CITY OF ALBUQUERQUE

July 1, 2015

RE: **HLP Endodontics, 10429 Lagrima Del Oro NE**
Grading and Drainage Plan
Engineer's Stamp Dated 6-29-15 (File: F21-D063)

SECTION B-B NTS

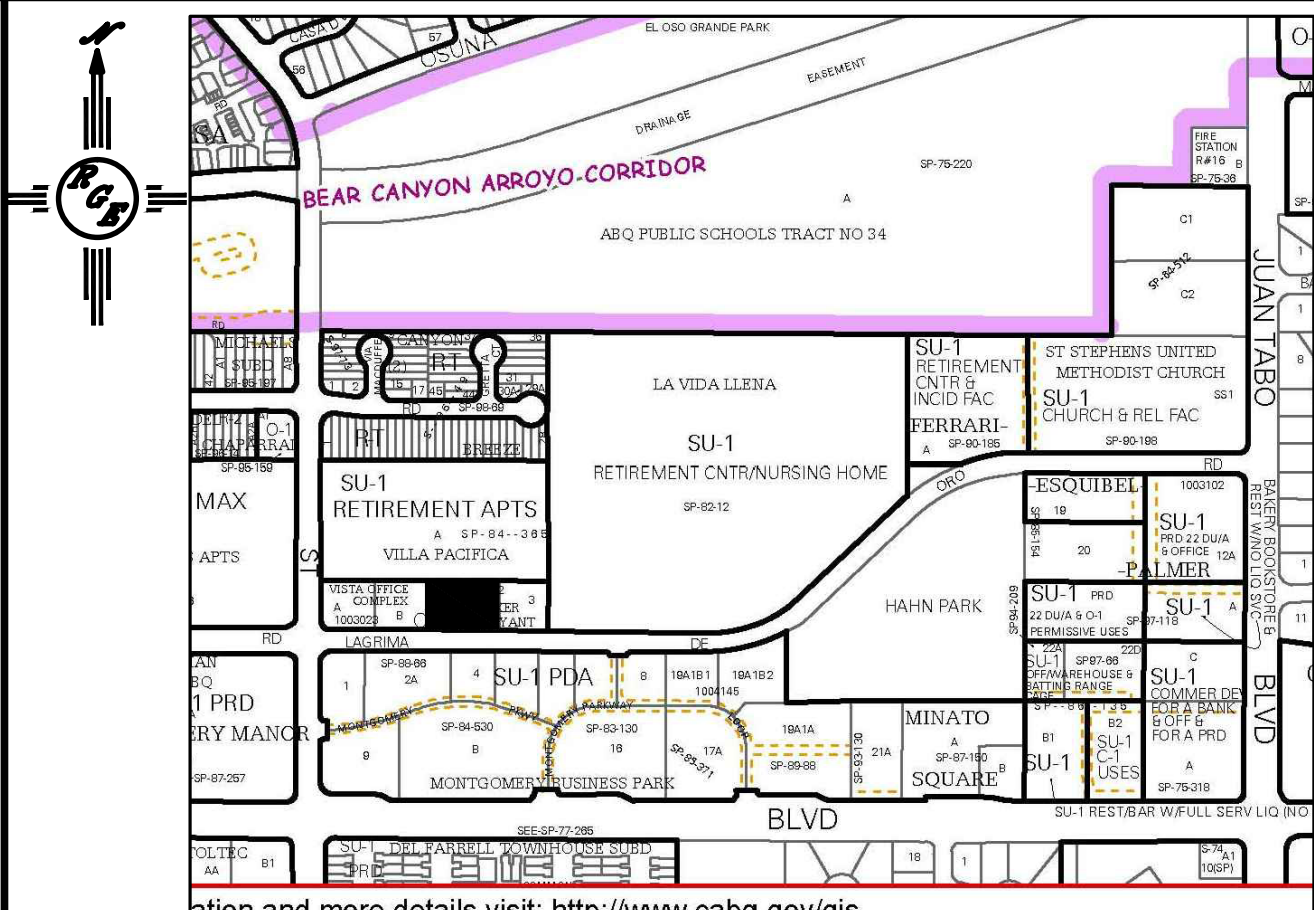
- A. On cross-section B-B, indicate a vertical dimension for the swale similar to A-A to ensure that there is a defined swale size. Provide minimum vertical depth of 8 inches.
- B. Provide a site benchmark.
- C. At the southwest corner of the parking lot, there is a 53.50 elevation which is a low spot and looks like it needs a curb cut. Provide a curb cut at this location.
